**KIRKLEES METROPOLITAN COUNCIL  
INVESTMENT & REGENERATION SERVICE**

**DELEGATED DECISION TO DETERMINE PLANNING APPLICATIONS**

Reference No:	<b>2026/62/90127/E</b>
Site Address:	Squirrel Lodge, 19, Liversedge Hall Lane, Liversedge, WF15 7DP
Description:	Demolition of existing garage, outbuilding and porch and erection of two storey side and rear extensions, single storey front extension, erection of front porch with balcony and associated alterations
Recommending Officer:	Edward Cheseldine

**DECISION - REFUSED**

Issue Purpose : HH Application		
Project	Proposed Single storey rear extension	Date 24-12-2025
		Scale 1:100 @ A3
Address	Squirrel Lodge, 19 Liversedge Hall Lane, Liversedge, WF15 7DP	Proposed plans
		D.N. 2025 - 19LHL - 05

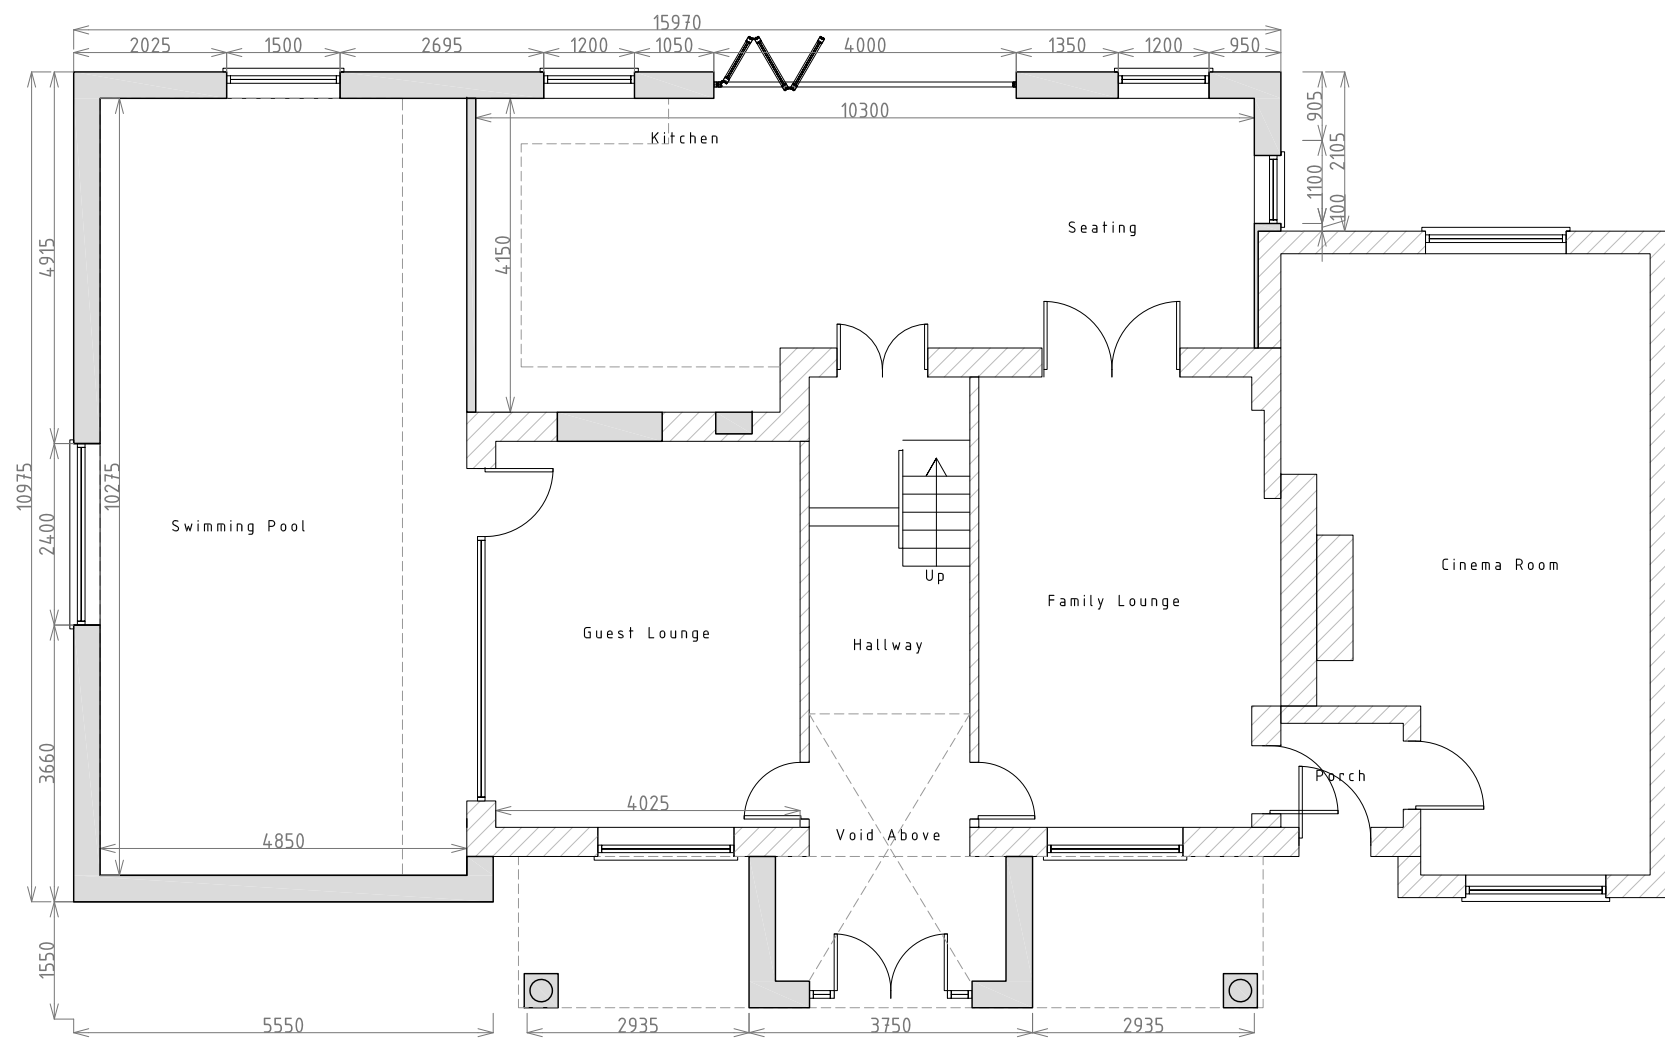
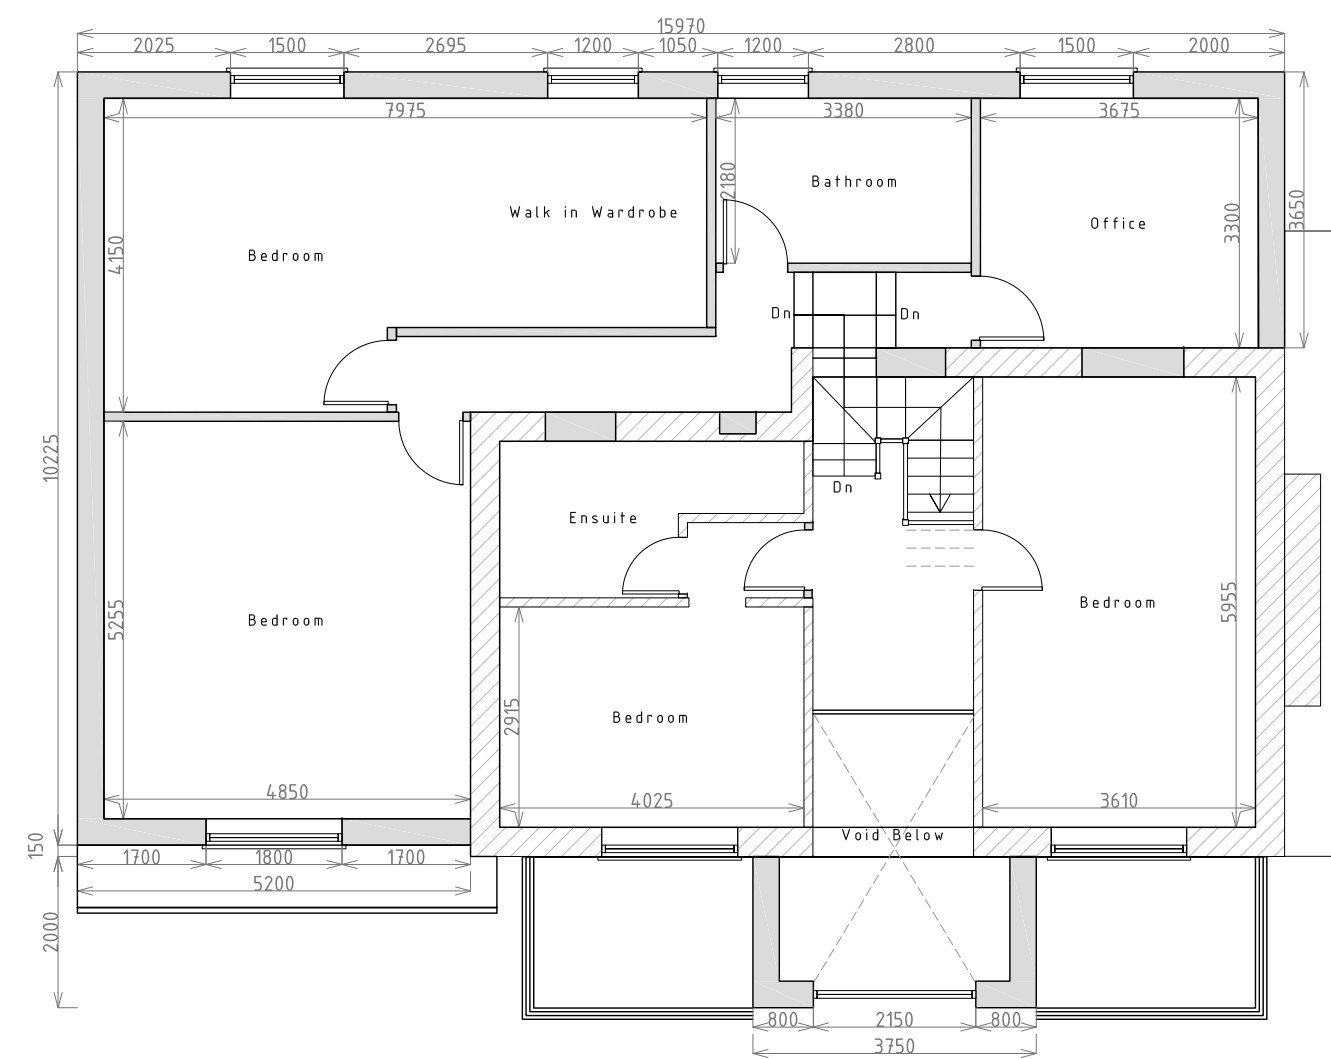
In terms of privacy, new first floor windows will be installed. On the first-floor level the nearest window is indicated as an office space. It projects an additional 3.65 metres from the existing windows which are currently bedroom windows.

In terms of impact, the nearest first-floor window lights an office and is angled away from the existing windows in No. 5. There will be a change to the observable distance to this property and its rear outdoor space; however, a garage provides some screening of the rear area, and additional soft

In terms of privacy, new first-floor windows are proposed to light a bedroom, which would be approximately 7.10 metres from the rear outdoor space of the neighbouring property. Currently, the nearest first-floor window on the existing property lights a bedroom and is set away from the position of the proposed bedroom windows. The garden of 2 Victoria Road is not currently overlooked, as surrounding buildings are either single-storey or have side-elevation windows with an angled line of sight toward this space. Figure 7 of the Kirklees House Extensions & Alterations Supplementary Planning Document advises that a distance of 10.5 metres should be maintained between habitable windows and undeveloped land to avoid overlooking into private areas. In this instance, given that the garden is not presently overlooked, the proposed arrangement would result in a loss of privacy, and the 10.5-metre separation should be maintained.

The applicant has indicated that the rear-elevation windows of the bedroom would be obscured up to 1.80 metres from floor level. This could reduce the amount of natural light available to future occupiers and is generally undesirable. In this case, Officers have not been asked to alter the internal layout of the building, as changes would require significant amendments.

The submitted plans confirm a poor standard of amenity to the first-floor bedroom within the rear elevation. This room is classed as a habitable room, would have no outlook and would receive limited light due to their contrived internal layout which includes obscured and high level windows. For these reasons, it is considered that the proposal would provide an unacceptable standard of living for future occupants and would fail to accord with LP24(b) of the Kirklees Local Plan, and Paragraph 135 (f) of the National Planning Policy Framework.

Issue Purpose : HH Application			
Project	Proposed Single storey rear extension	Date	24-12-2025
		Scale	1:100 @ A3
Address	Squirrel Lodge, 19 Liversedge Hall Lane, Liversedge, WF15 7DP	Proposed roof plan	
		D.N.	2025 - 19LHL - 06

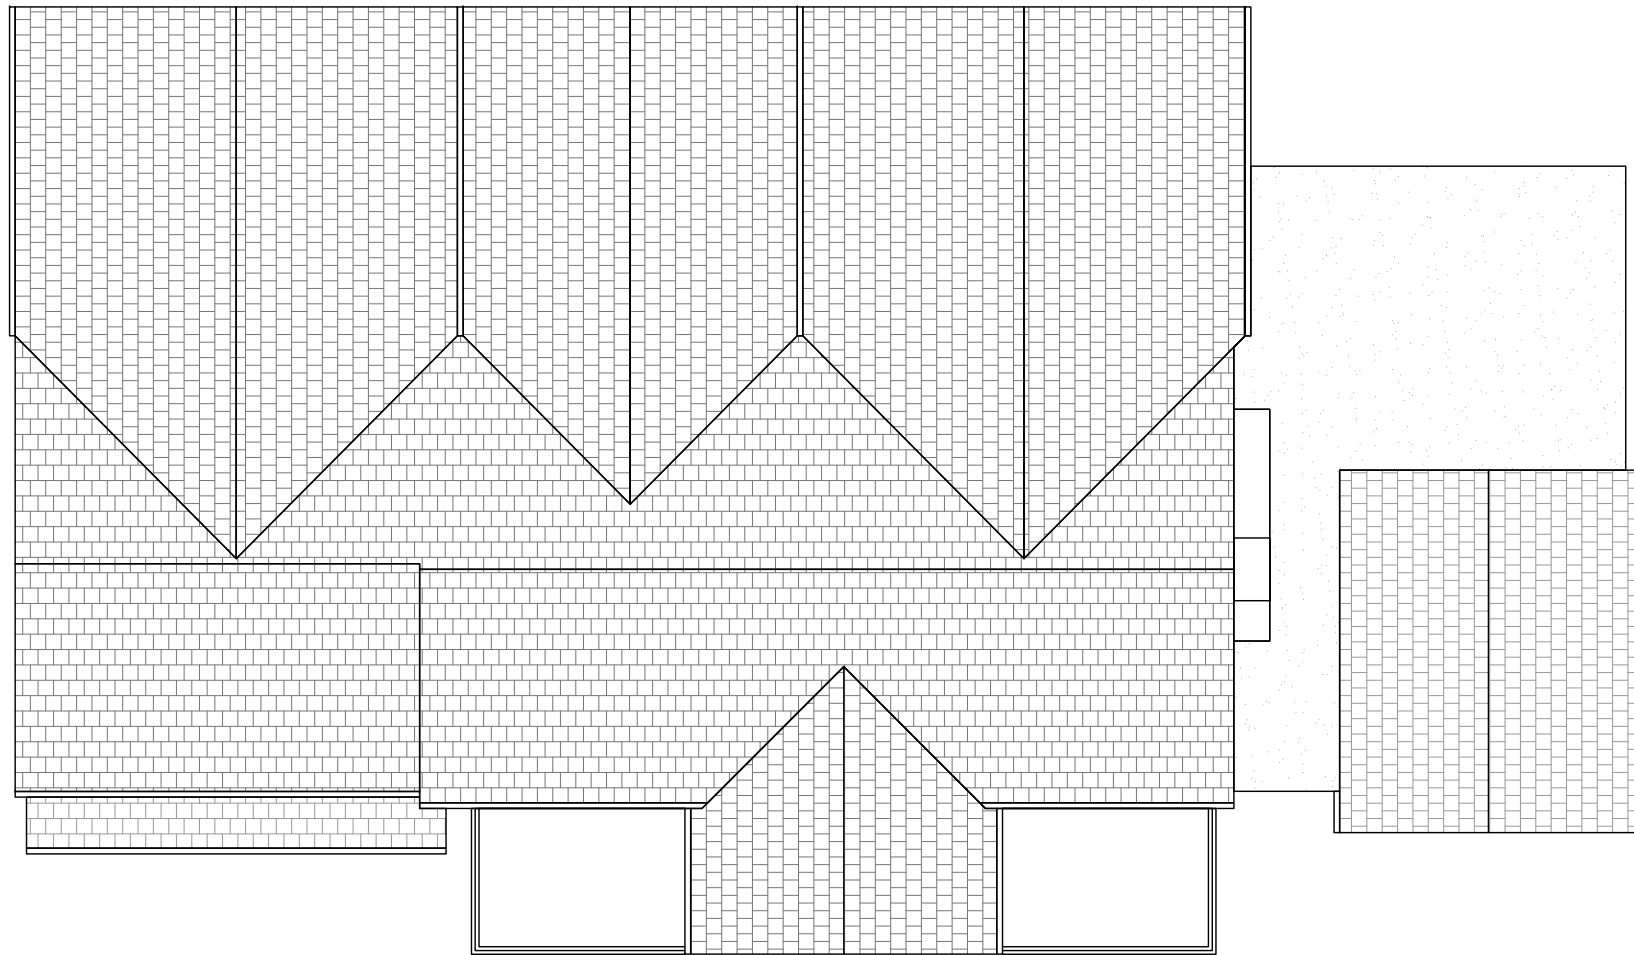
The two-storey rear extension will be 16.00m(w) x 3.65(l) with a ridgeline height of 7.15m. The roof will be formed of three gable-ends with valley gutters. Walling materials will be tumble stone with stone roof slates.

Additionally, the view from rear windows will be affected due to the extensions. From the rear bedroom window, the skylights may be visible from these windows, this would only occur at an angled view towards the ground-floor roof. The skylight windows are positioned at a high level. Considering the changes in angle and height, there is sufficient mitigation, and the impact is therefore considered acceptable.

Issue Purpose : HH Application		
Project	Proposed Single storey rear extension	Date 24-12-2025
		Scale 1:100 @ A3
Address	Squirrel Lodge, 19 Liversedge Hall Lane, Liversedge, WF15 7DP	Proposed Elevations
		D.N. 2025 - 19LHL - 07

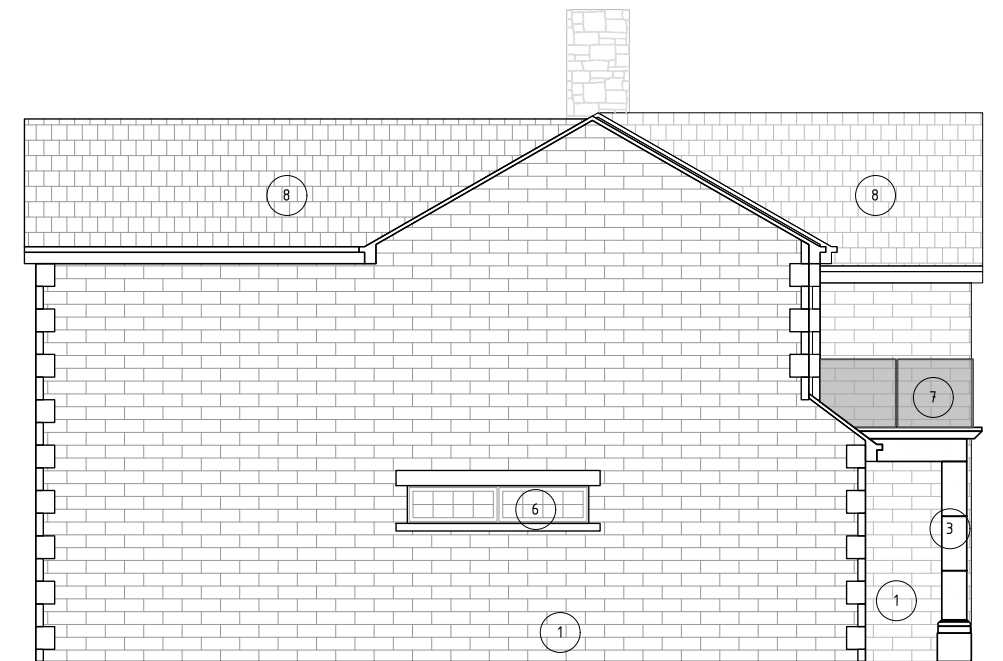
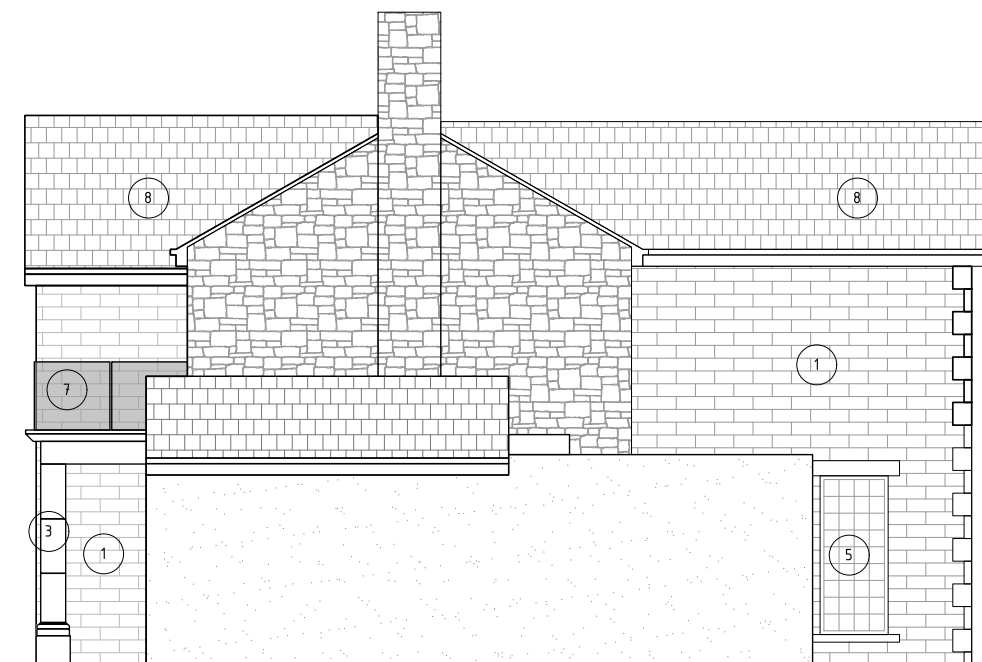
In relation to the host dwelling, the proposed side extension would increase the width of the building by 5.20 metres, representing an approximate 50% increase to the width of the front elevation. The extension is set down from the main ridgeline by only 10mm, which is a negligible reduction and fails to meaningfully offset the increased massing. Furthermore, the extension is not set back from the principal elevation.

As a result, the design of the proposal does not adequately mitigate the additional mass created by the extension to the side of the dwelling. When viewed from the public realm along Liversedge Hall Lane, the extension would appear as a continuation of the existing building, resulting in a bulky and dominant form.

In this case, a two-storey glazed front extension is proposed. The extension would measure approximately 3.75 metres in width across the front elevation and extend up to the height of the main ridgeline of the dwelling. As a result, the proposal would significantly increase the bulk of development at the front of the property, creating an overly large and visually prominent addition.

The ridgeline of the extension would project approximately 4.70 metres forward of the main ridgeline of the dwelling. Given that the existing dwelling has an overall depth of approximately 5.80 metres, this projection represents a substantial proportion of the building’s depth. Consequently, the extension

would appear top-heavy, with the forward projection disrupting the existing horizontal roof form and resulting in an unbalanced appearance.

The extension would be fully glazed up to roof level, resulting in a prominent and visually dominant feature. The extensive glazing would contrast sharply with the natural stone walls of the original dwelling, detracting from the character and architectural features of the property.

In terms of privacy, the proposed includes a high-level side-elevation window that provides light to the swimming pool area. Elevation plans indicate that this window will be obscure-glazed. If the application were approved, a condition would require this window to be obscure glazed to protect the privacy of neighbouring and future occupiers.

A balcony will be positioned at the front of the building, providing a view of approximately 6.80 metres towards the private outdoor space of this property. If the application is approved, a condition will require the installation of a privacy screen to mitigate these views, given their proximity.

A balcony will be positioned at the front of the building, providing a view of approximately 5.40 metres towards the private outdoor space of this property. If the application is approved, a condition will require the installation of a privacy screen to mitigate these views.
